From: Julie Grieves on behalf of Planning.Responses
Sent: 29 October 2012 17:52
To: Anita Gardner
Subject: FW: Ref R/193/12
Attachments: Pikett - 29-10-2012 A3 Elevations sheet 1 (E).pdf; Pikett - 29-10-2012 A3 Elevations sheet 2 (D).pdf

From: Brian Elstone [REDACTED]
Sent: 29 October 2012 16:45
To: Planning.Responses
Subject: Ref R/193/12

Please find attached revised elevation drawings for your use.

Revision	Date	Description
Client:		
Mr & Mrs Pikeitt		
Project:		
Land next to 2 Cross Road, Rustington		
Drawing Title:		
Elevations sheet 2		
Scale:	Date:	Drawn By:
1:100	27-01-2012	BE
Drawing Number:		Revision:
1056/008		D

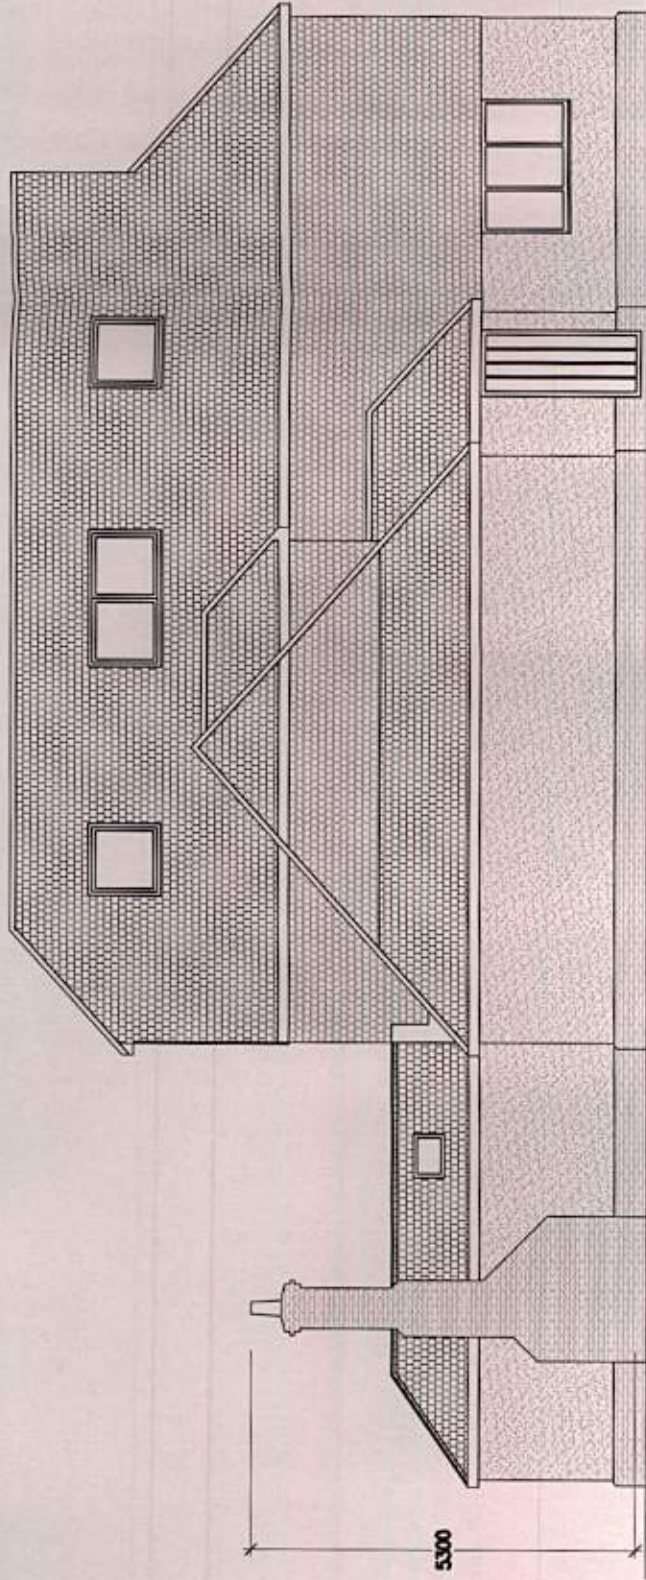
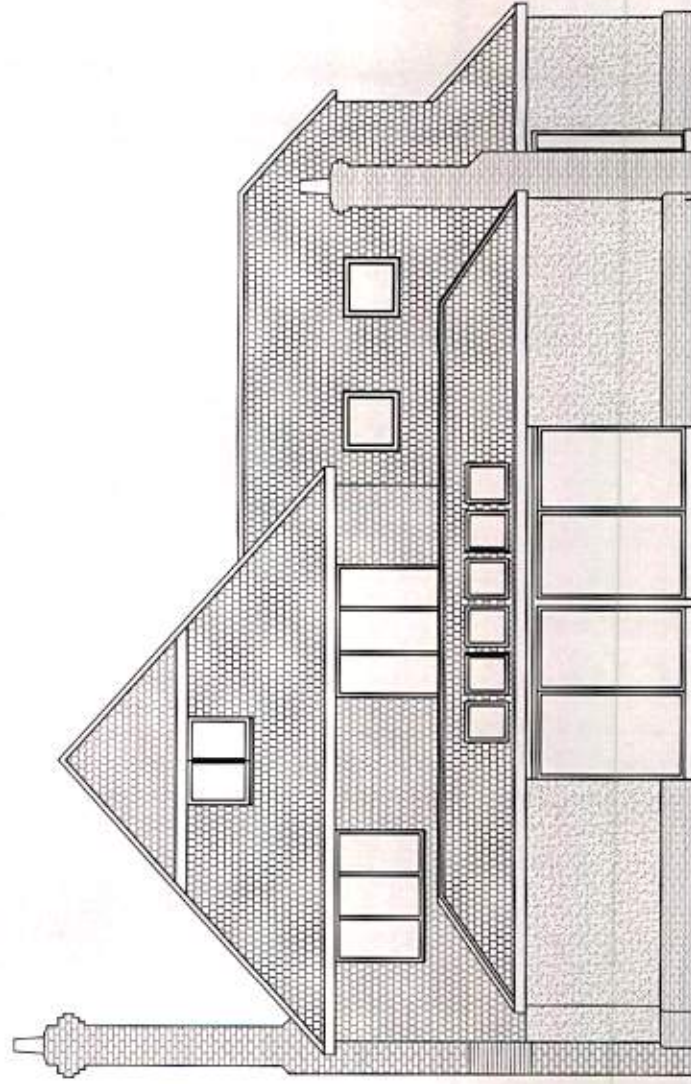
Following detailed discussions with the building control officer and fire place manufacturers it has transpired that the chimney to the rear of the property was not tall enough to draw with out the aid of a fan.

As the property is being designed and built with running cost in mind this was deemed unnecessary and we therefore have raised the chimney a little.
